Your Ref: OWPC10276
Our Ref: AL/83/16/OUT 15-08-2016
Please ask for:
Mr S Davis

Outline application with all matters reserved for residential development of up to 8No. dwellings & associated works including access, landscaping & open space. This application is a Departure from the development plan. Resubmission of AL/8/16/OUT Land south & west of Barnside & east of pond Hook Lane Aldingbourne

Thank you for your internet representation made on 30th August 2016 which has been recorded as '**an objection**' with the comments as follows:

Client	Whitgift Estates			
Project	Hook Lane, Aldingbourne			
Drawing Title	Access Visibility Splays			
Scale	1:500 @ A3	Drawn By	RAA	Checked By
Drawing No.	2015/2717/002	Date	December 2015	Approved By
				PMR
				Rev.
				A

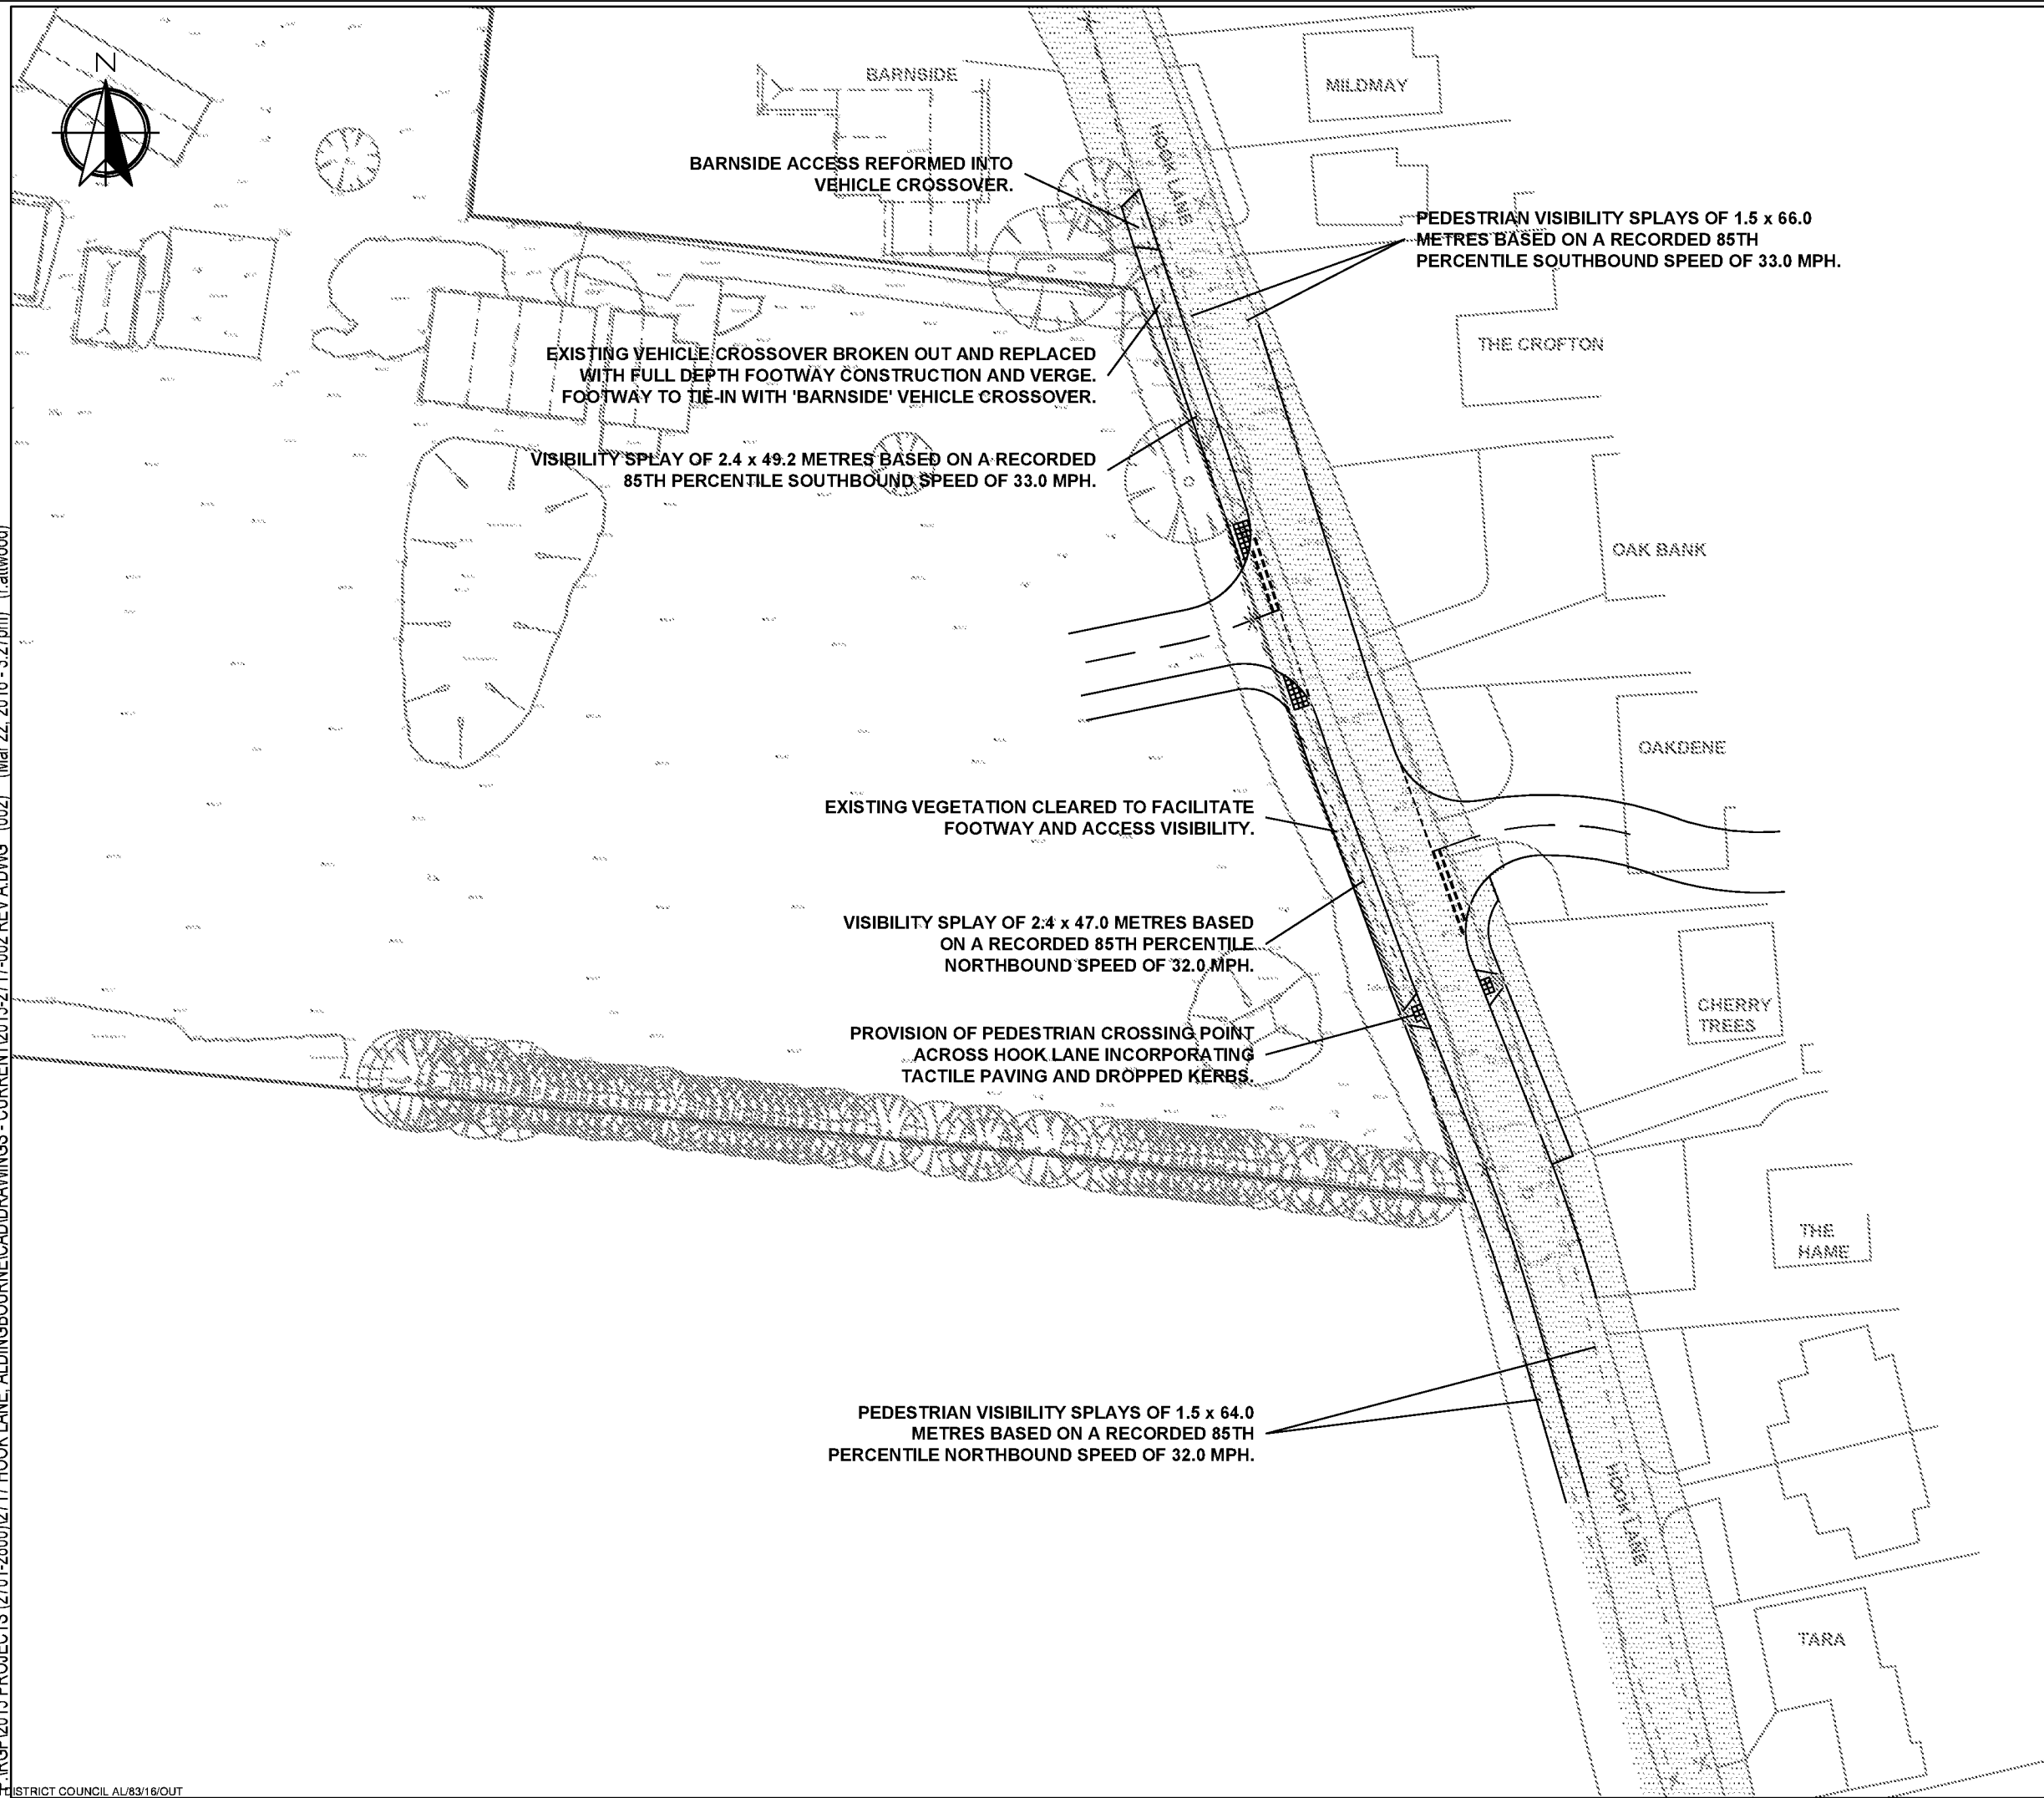
There is existing planning permission for an estate with access onto Hook Lane opposite this site. If permission were granted it would create a very dangerous junction on Hook Lane at one of it's narrowest points. Also, it is outside the Parish development area and would cause environmental damage due to the destruction of wildlife habitat.
